M25 junction 10/A3 Wisley interchange

ELM CORNER

This submission was compiled by Elm Corner residents working together to present a collective response for all 16 properties. We hope the examiner will therefore forgive its length.

Elm Corner is a cul-de-sac and a historical hamlet comprising 16 properties. The only viable vehicular access to Elm Corner is via Elm Lane directly onto to the southbound A3 south of the M25 junction 10. Highways England propose widening the A3 to four lanes at this point and to close the existing access to Elm Corner, constructing an alternative access road via BOAT 525.

Drawing Title	WORKS PLANS REGULATION 5(2)(j) SHEET 24 OF 31	
Drawing Number	TR010030/APP/2.3	Rev: 2
HE PIN: HE551522	Scale: 1:1000	Original Size: A1

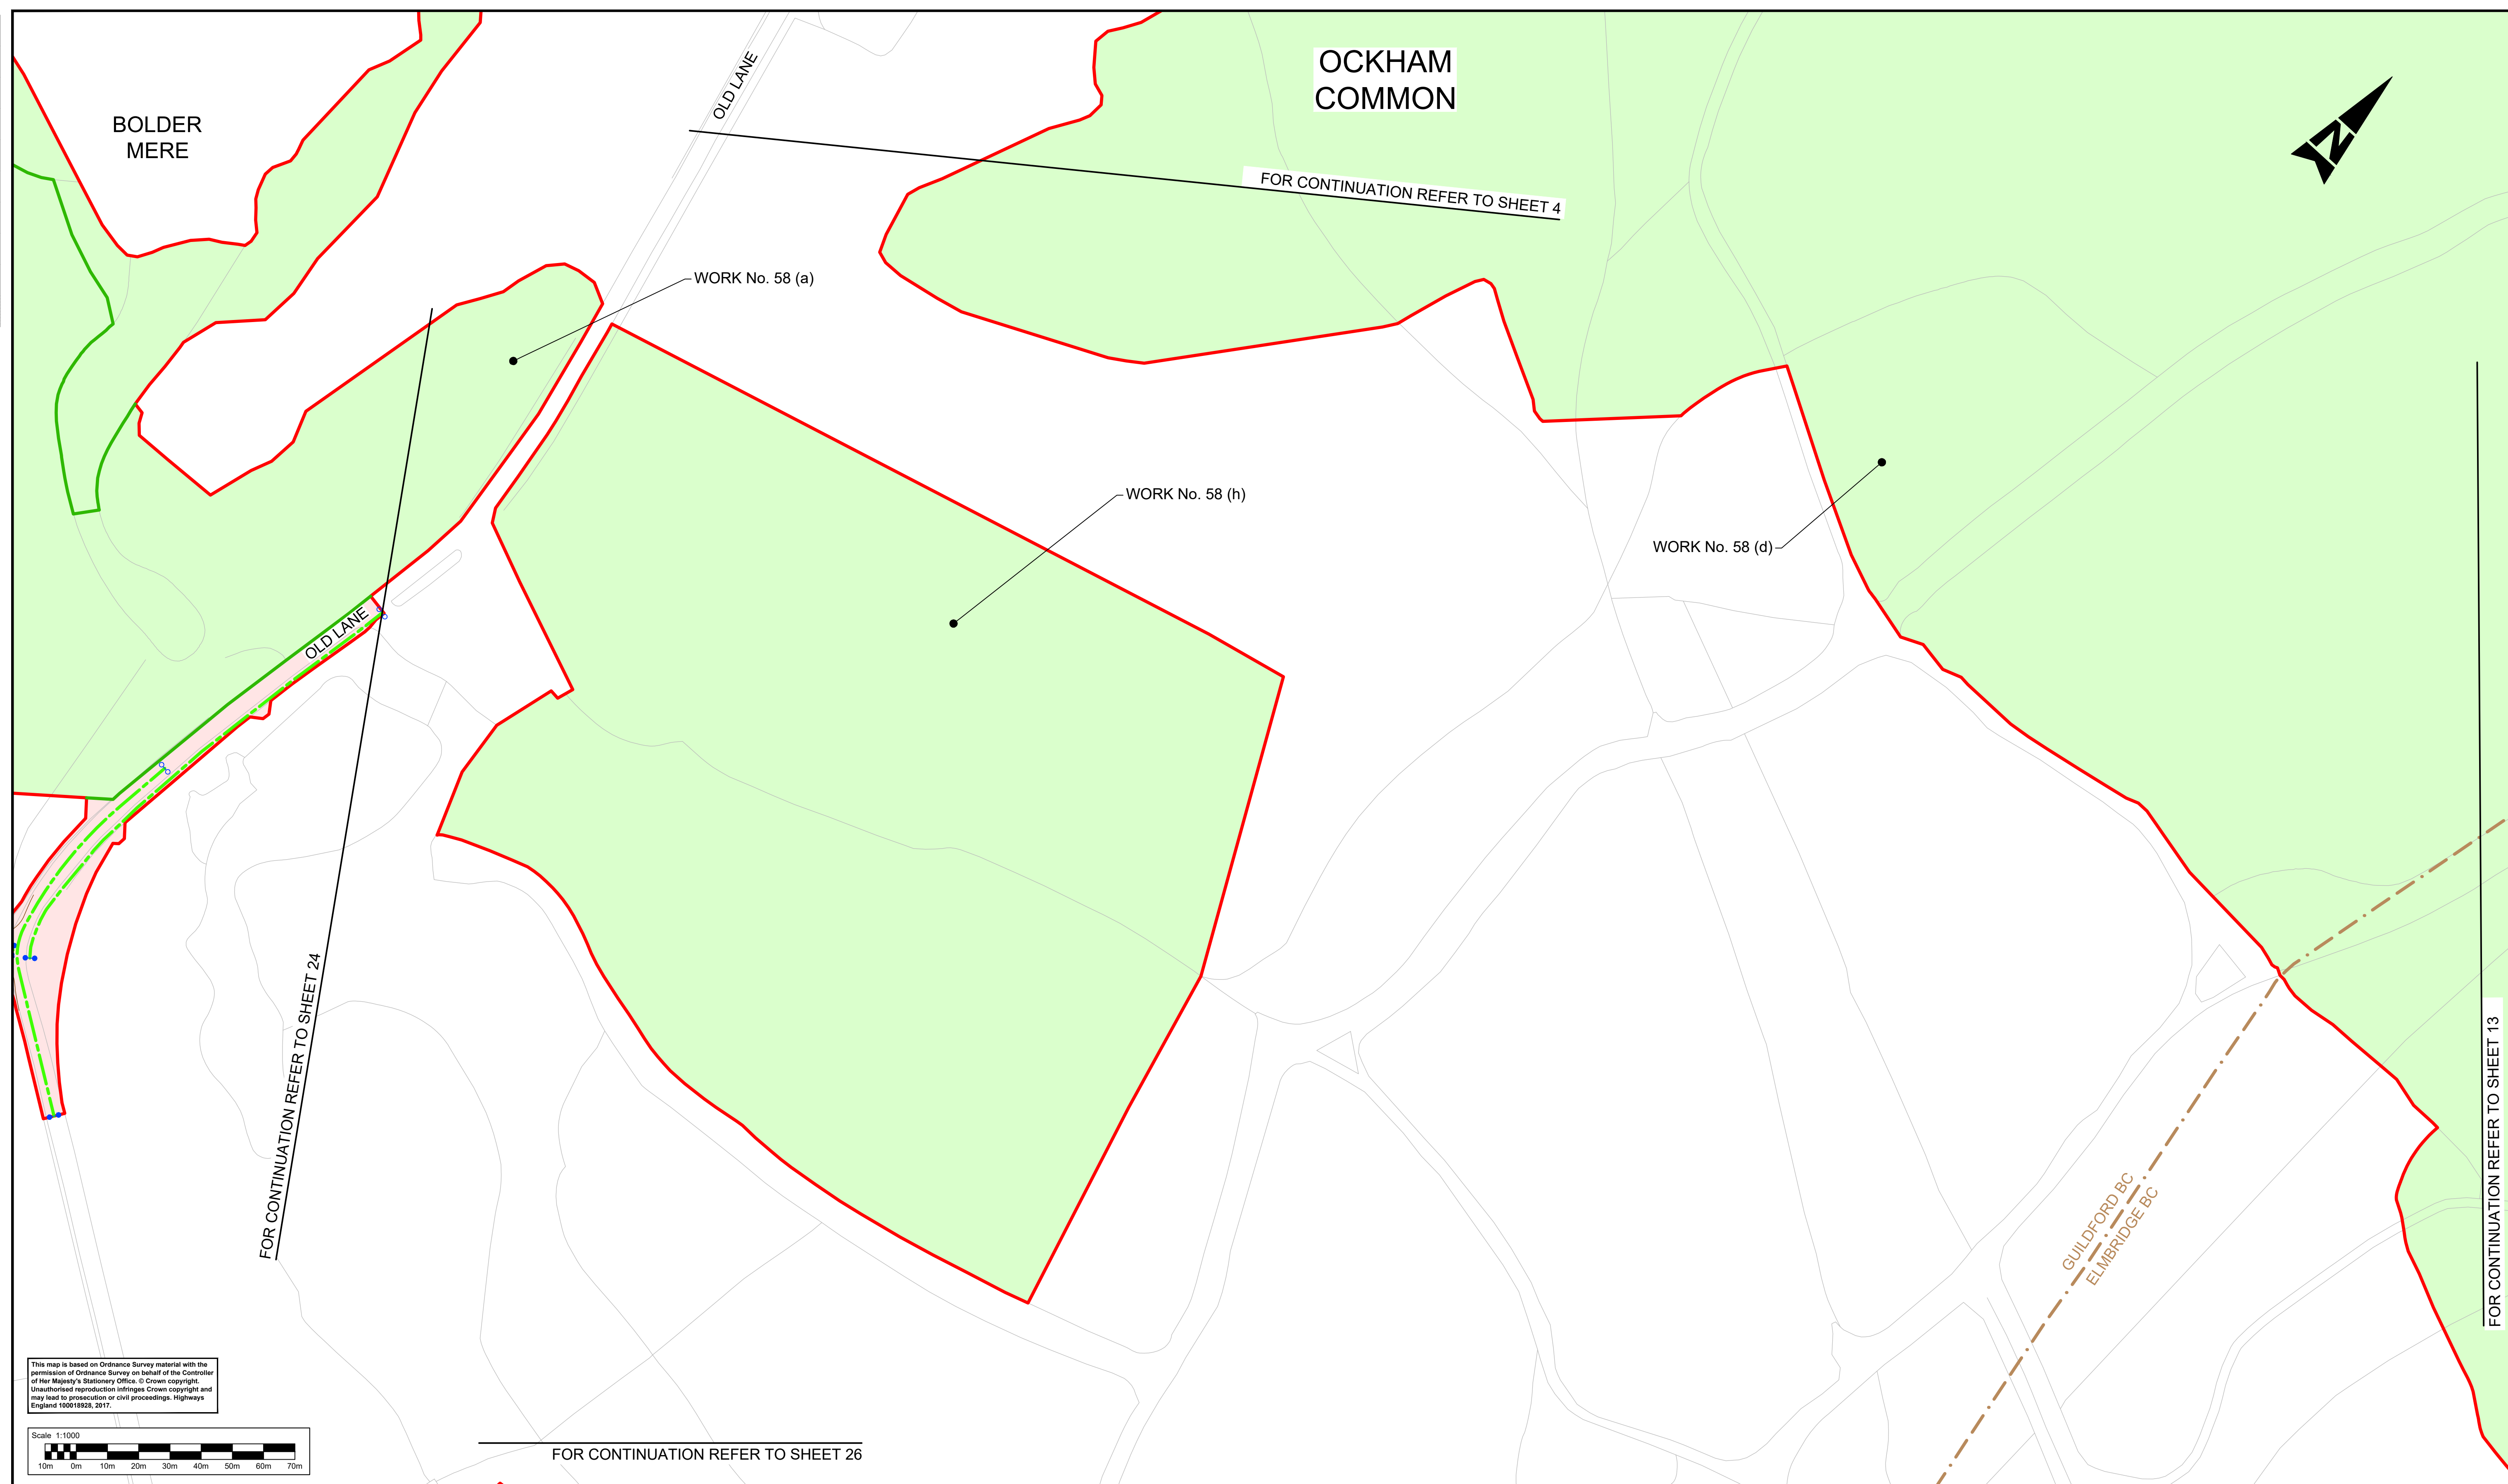
We are not able to ascertain any detail about the hammerhead turn proposed for Elm Lane.

What land is intended to be taken, when and for how long?

How will Elm Corner residents access their properties during the construction phase of the hammer head? [Plan Ref 24/1; BoR p430].

The hammerhead / turning circle should be designed specifically for vehicular manoeuvre and in such a way that it does not encourage parking or anti-social activity for the reasons set out above. Plans for the construction stage suggest a temporary turning circle in the land to the East of Orchard Cottage by the sub-station. An email from HE to the owners of Orchard Cottage suggests this would be adopted as a permanent turning circle for the operational stage. We would like to see this sensible and agreeable solution drawn into the plans in addition to stopping up Old Elm Lane immediately beyond the drive to Orchard Cottage on the west side. The Orchard Cottage driveway should under no circumstances be used for turning. We request that Elm Lane residents, such as Orchard Cottage, 2012 and 1 & 2

Fellside Cottages are consulted about the precise location and design of the turning circle and/ or hammer head turn and working space proposed for the tie-in of Elm Lane with Elm Corner [Plan Ref 24/1].
